TBT ENGINEERING CONSULTING GROUP

TBTE Ref No: 26-0120

Subject: City File Number: D02-02-24-0029
Update to Hydrogeological Study Report
Concept Plan (April 2026)
2095 Dilworth Road
Ottawa, Ontario

Drawing file: plan / All_Image Referencing_Zoning Bylaw Amendment Application_Image Reference_2025-10-31- Concept Plan - D02-02-24-0029.PDF

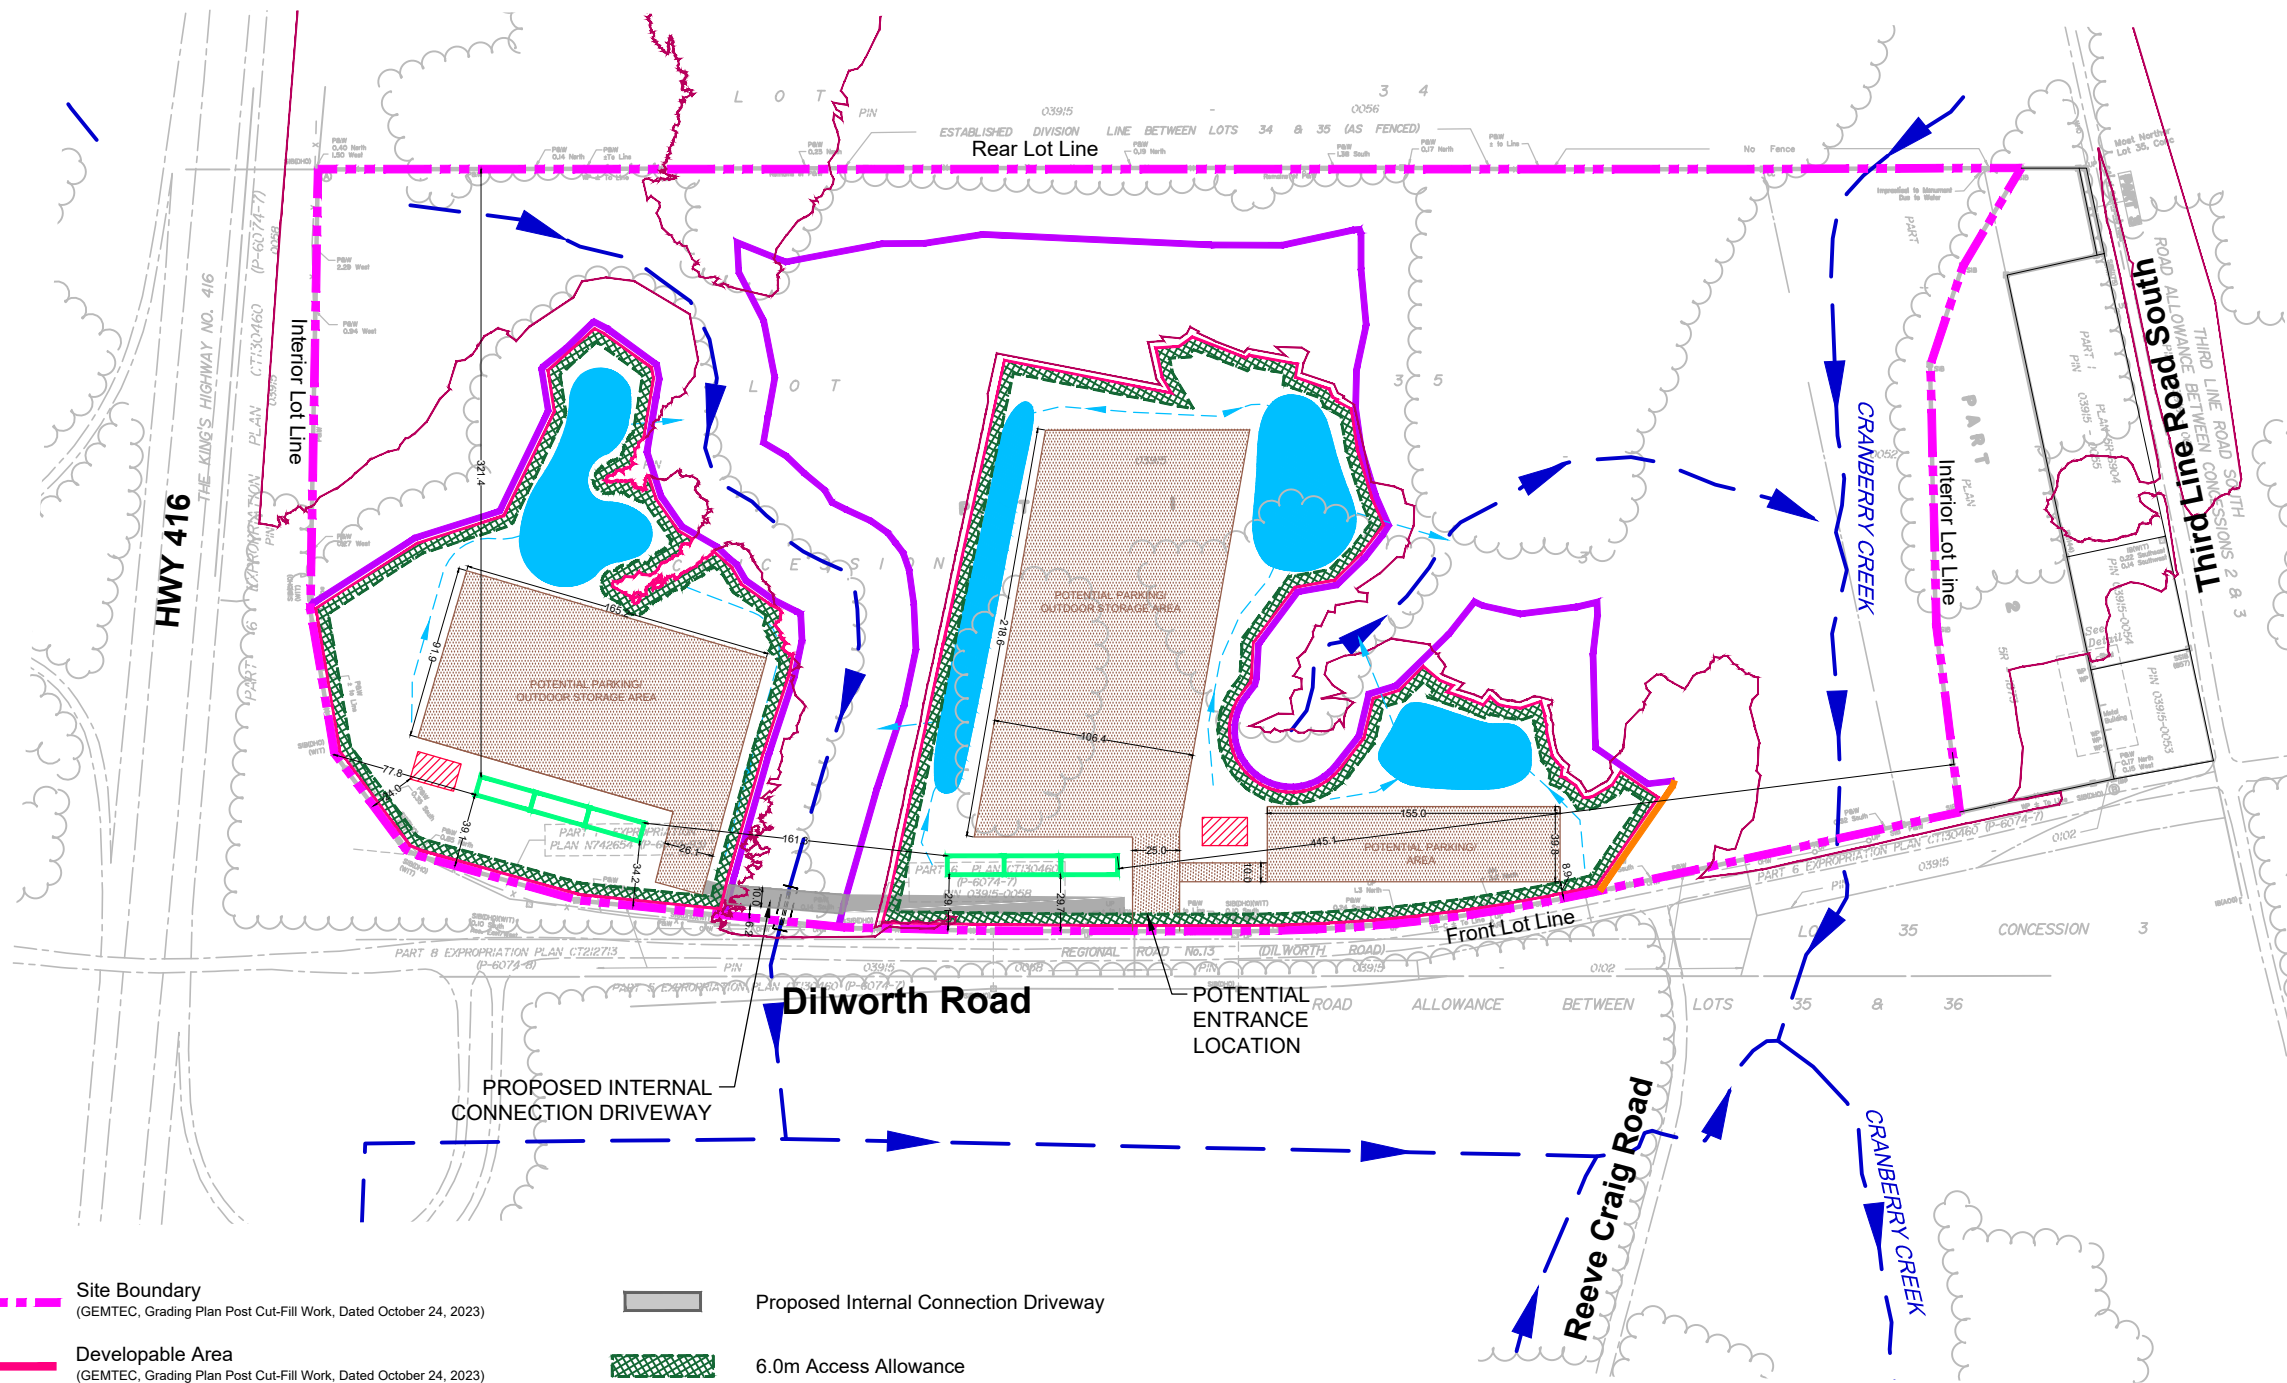
The current potential concept plan (refer to Attachment A) shows a building on each developable area with three (3) tenants each, with a space of 300 m² each. The following are the permitted uses for the property:

To present a potential "worst-case scenario" for development use based on the current potential concept plan, the following scenario includes permitted uses with the worst-case demands and related assumptions.

- Tenant uses within the buildings would include:
 - **Building 1**

- **Unit 1:** A car wash featuring 6 **self-serve** wash bays and two (2) employees.
- **Units 2 and 3:** Two separate store / retail units, each accommodating eight (8) employees.
- **Building 2**
 - **Unit 1:** A retail fuel outlet with ten (10) fuel pumps and two (2) employees.
 - **Units 2 and 3:** Two separate store / retail units, each accommodating approximately 8 employees.
- Water consumption for each unit would be restricted to **non-potable uses only**.
